DECISION DELEGATED TO HEAD OF PLANNING

Application No: H16-0331-26 **Applicant:** Mr A Odupitan

Proposal: Change the use from a 6 bed HMO (Class C4) to 7 bed HMO (Sui Generis)

Location: 40 Stonegate Spalding

SHEET NO.
P200
PROPOSED FLOOR PLANS

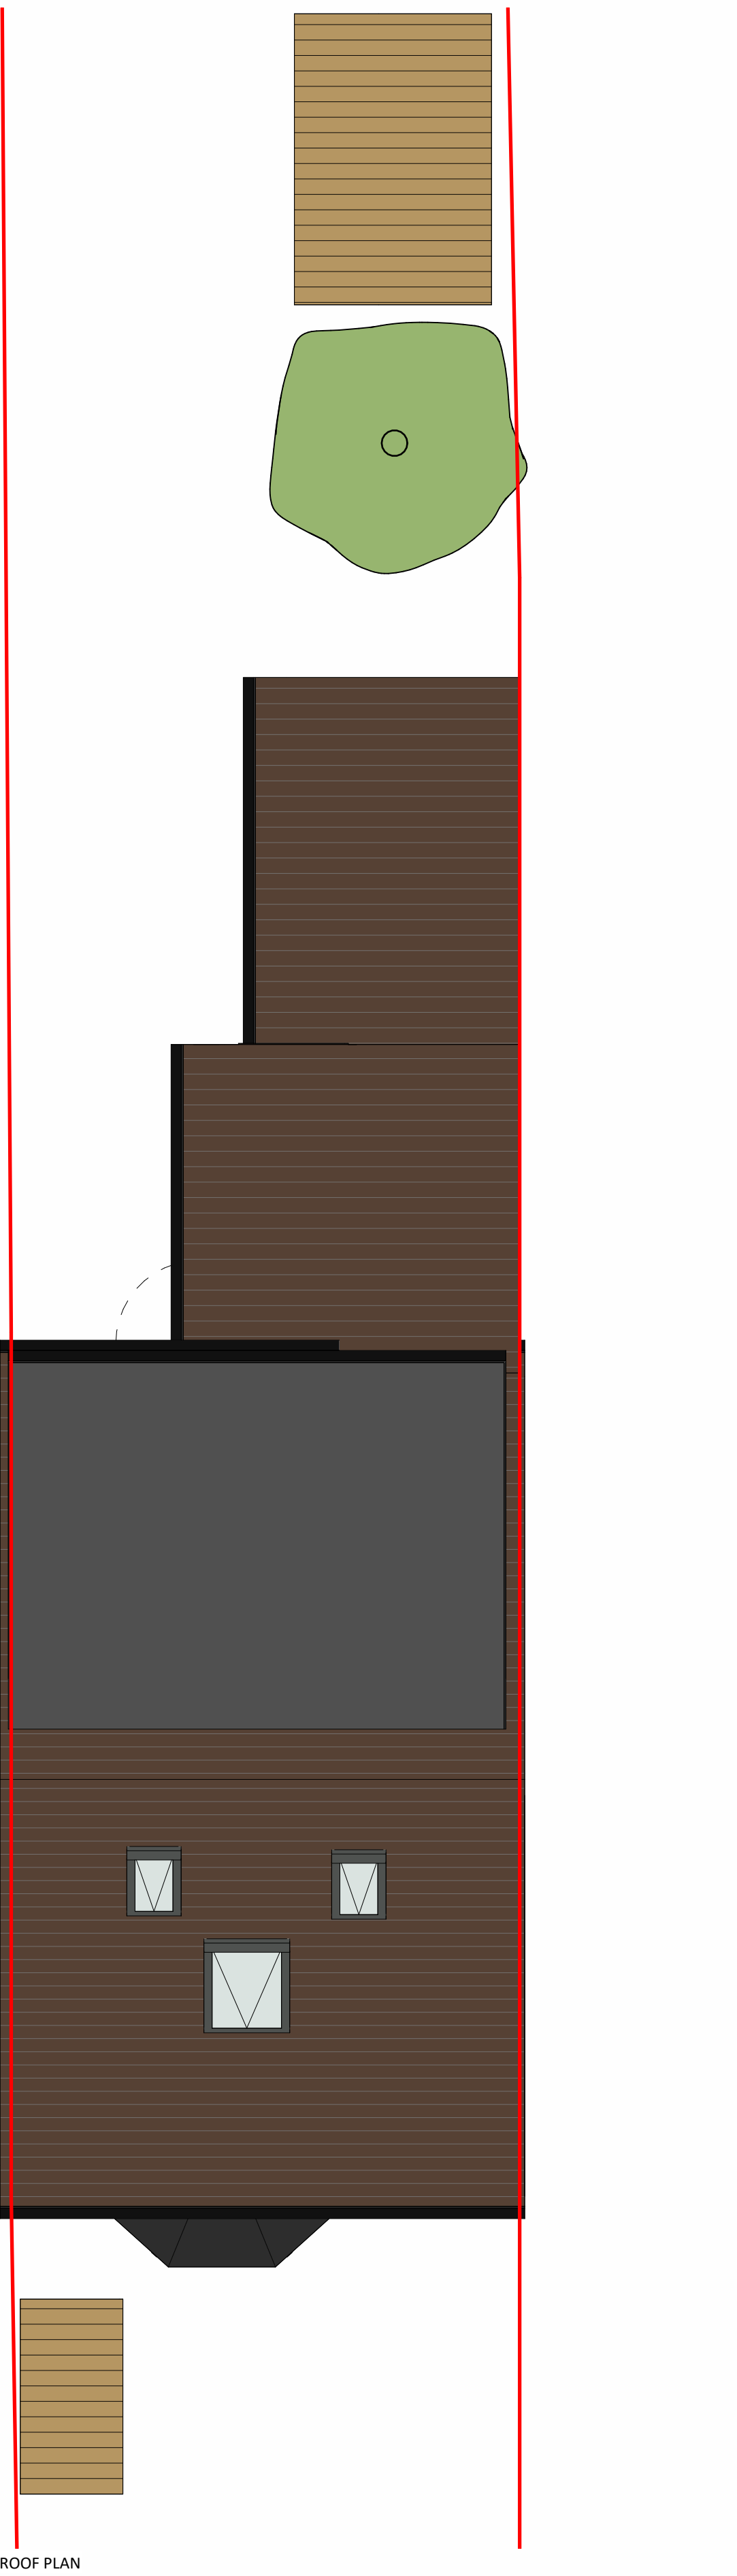
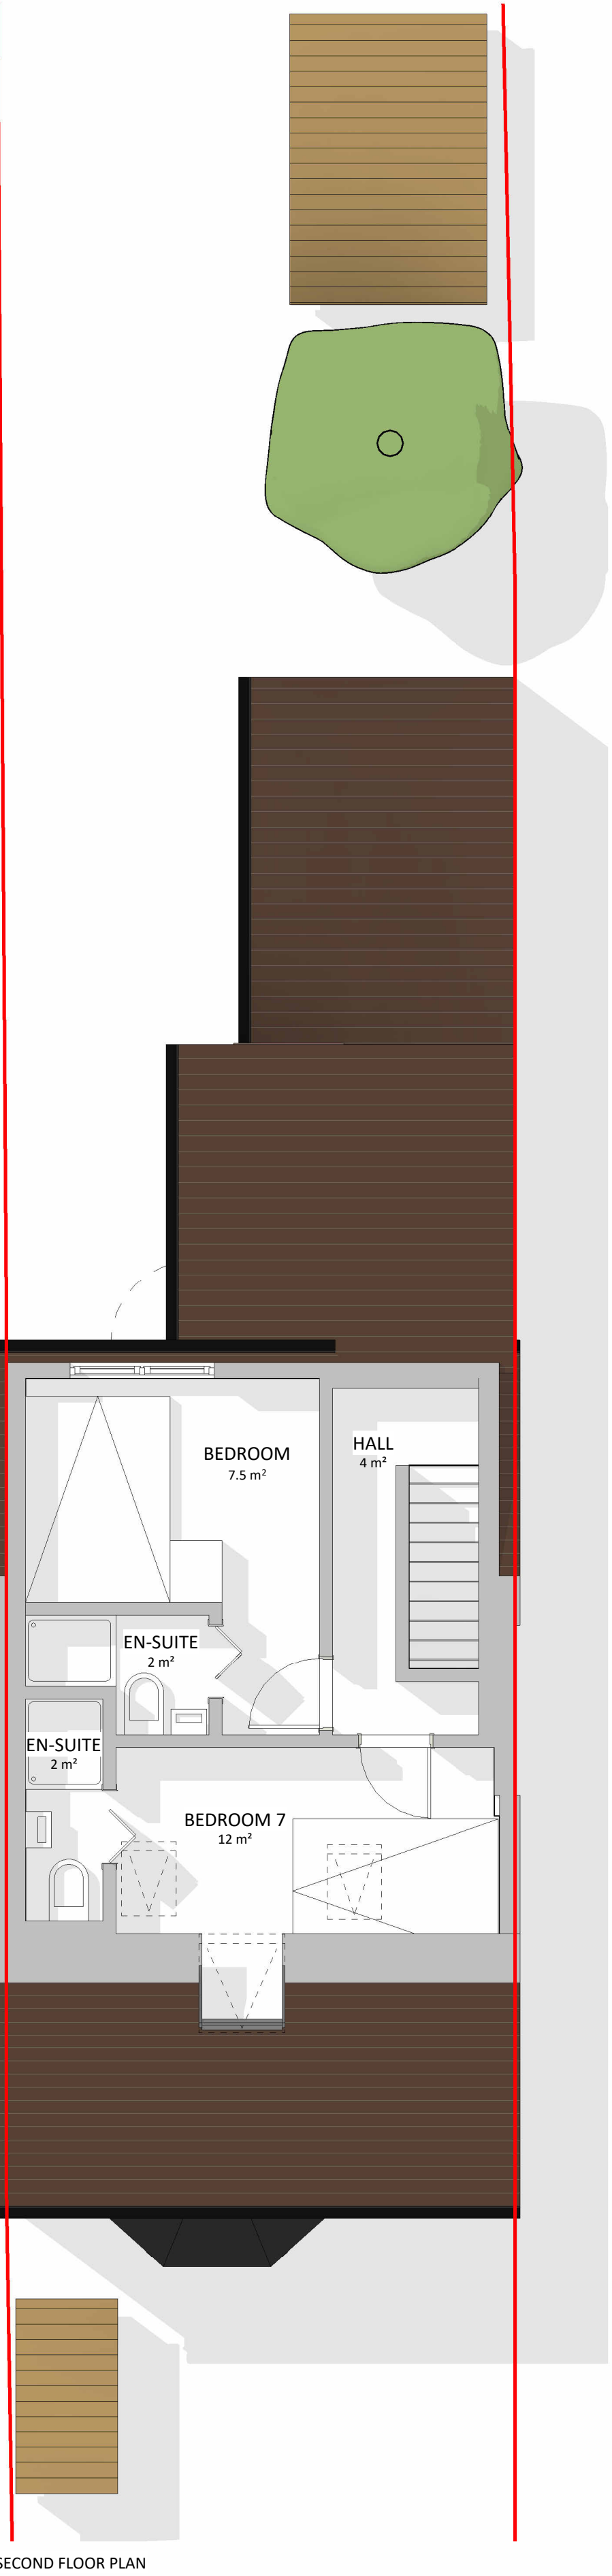
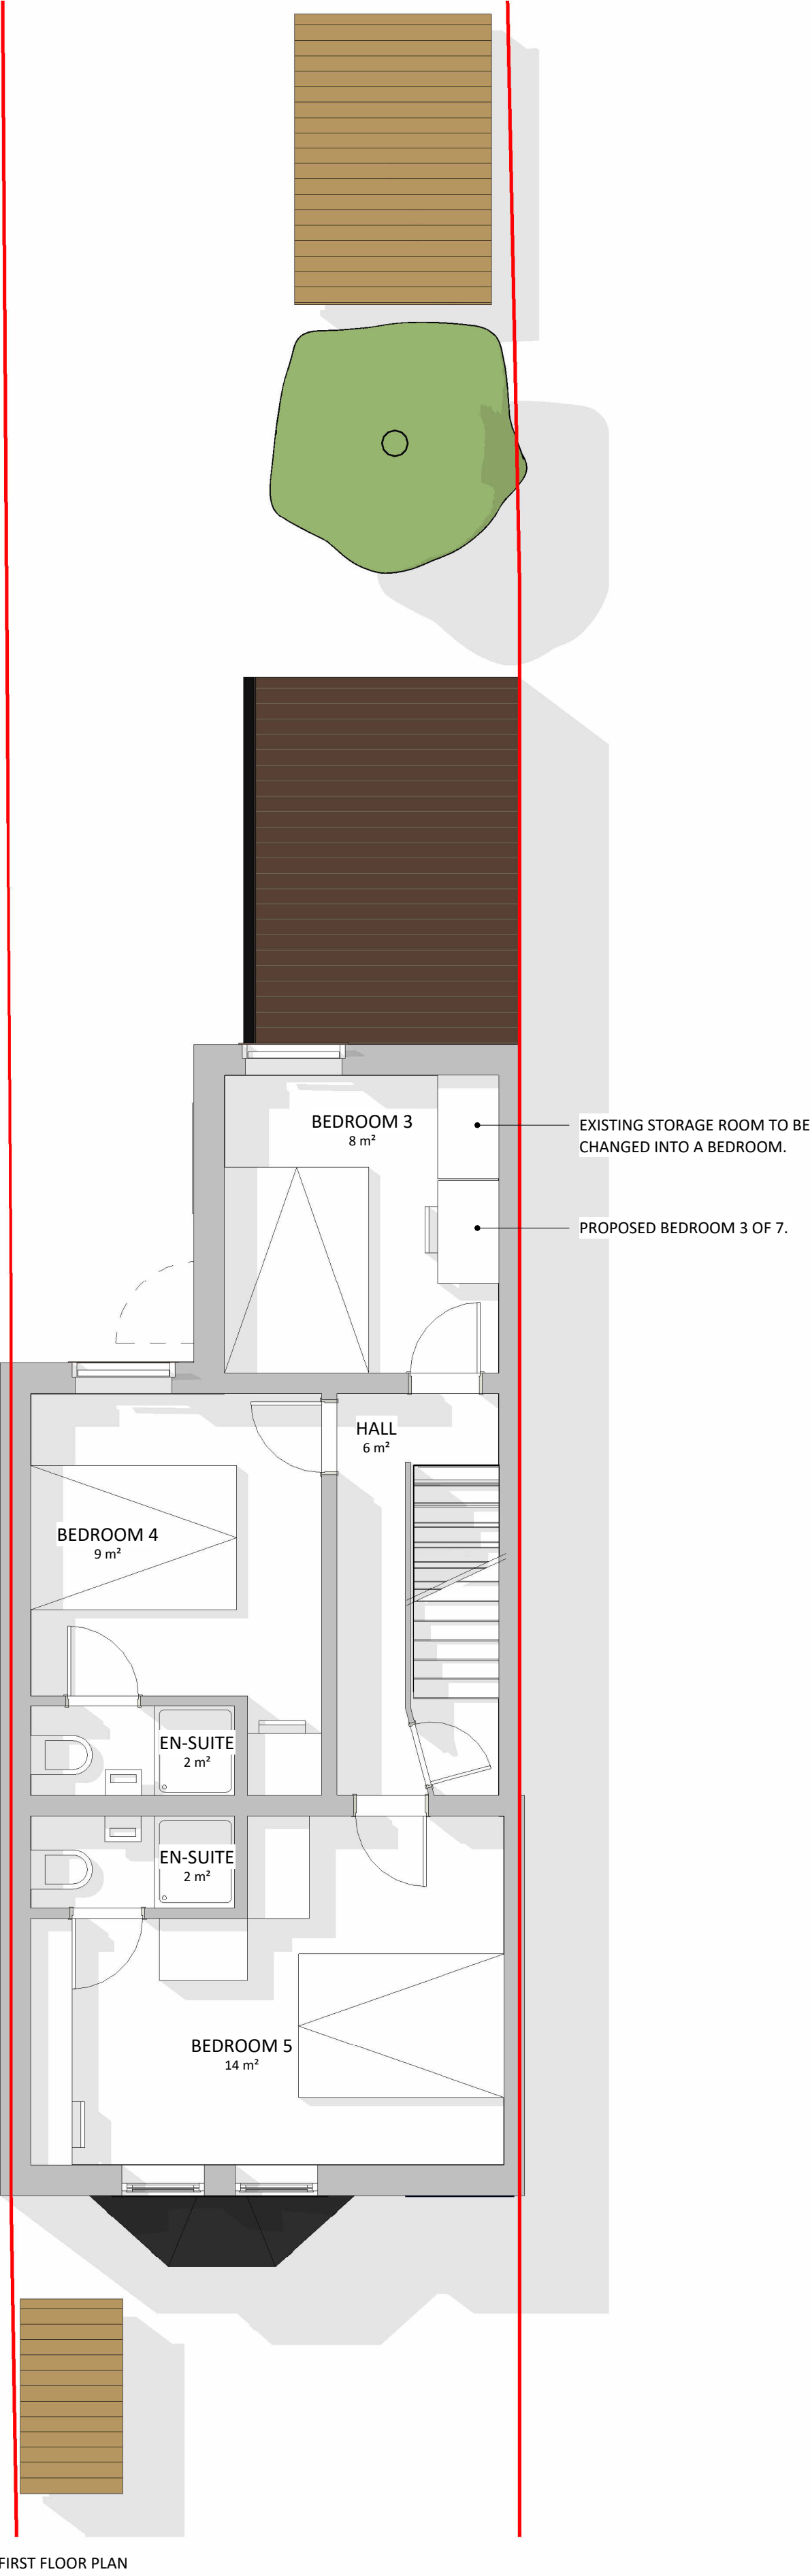
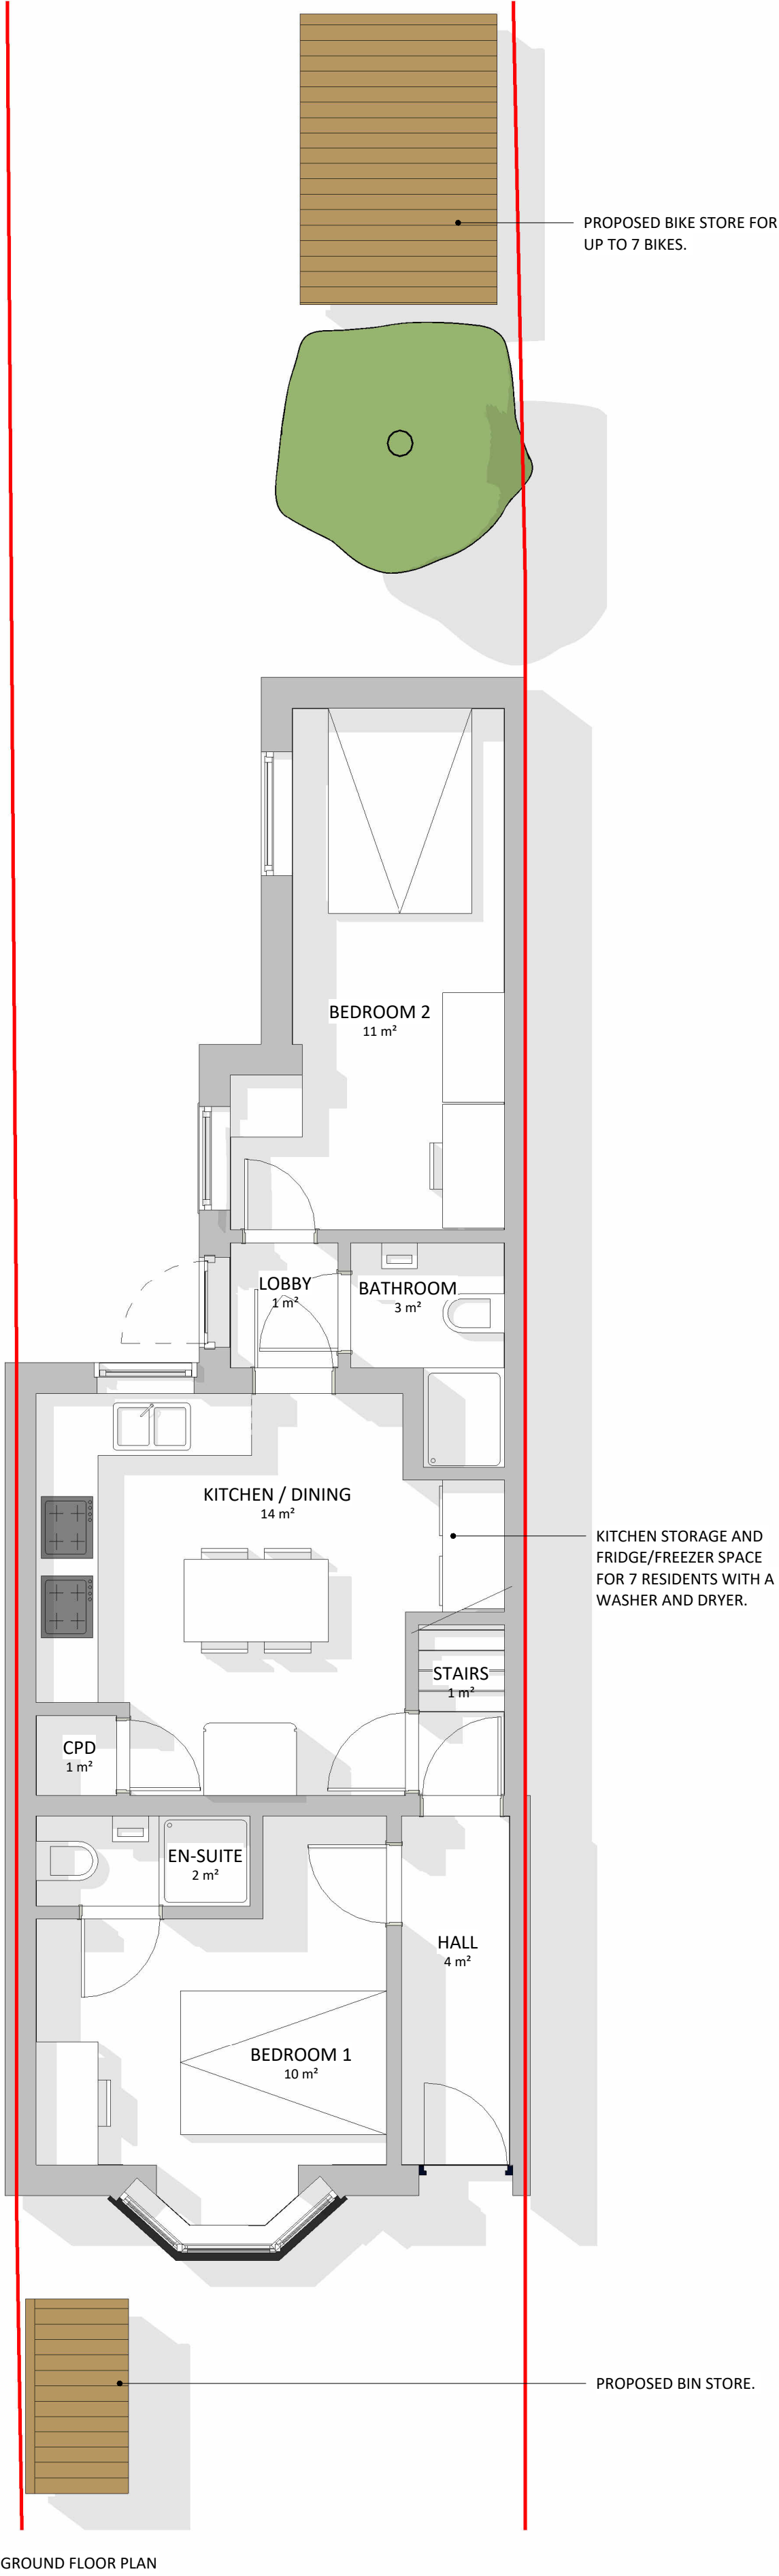
Objection. I viewed this property a few years ago when they asked for it to be a 6-bedroom HMO. I thought at the time it was small and tight for 6 without adding another room so this is beyond the scope of this property.

The property has recently been subject to complaints of poor management of waste likely to attract pests. additional occupants and reduces facilities for storage are unlikely to improve this situation. proper facilities for storage and management of waste must be included.

The proposal seeks to increase the size of the existing 6-bedroom HMO to a 7-bedroom HMO. This would entail changing the use of the laundry/storage room within the site into a bedroom. No external changes are proposed.

It is considered that the kitchen would be suitably sized for the proposed number of bedrooms; however, it would be considered appropriate to include a planning condition to restrict the number of occupants within the HMO due to the size of the kitchen. As such, the proposal is considered to accord with Policy 21 of the Local Plan.

In this case, the site comprises an existing 6 bedroom HMO, and the proposal would result in the provision of an additional bedroom, resulting in a 7 bedroom HMO. The proposed bedroom, that subject to this proposal would be located to the first floor and as such, this proposal would not result in the creation of additional ground floor living accommodation.

In terms of part 4, Environmental Protection have raised objections to the proposal due to complaints of poor management of waste by the existing residents. Comments have been raised with regards to the additional occupants and reduced facilities for storage which are unlikely to improve the situation. However, a new bin store will be located to the front of the site and a condition has been attached to submit a storage and management of waste plan, which is considered to be sufficient to satisfy part 4 of Policy 21.

The comments from the EA also advise that "a Flood Warning and Emergency Response (FWEP) plan" should be provided. As such, a pre-commencement condition has been recommended to obtain this information.
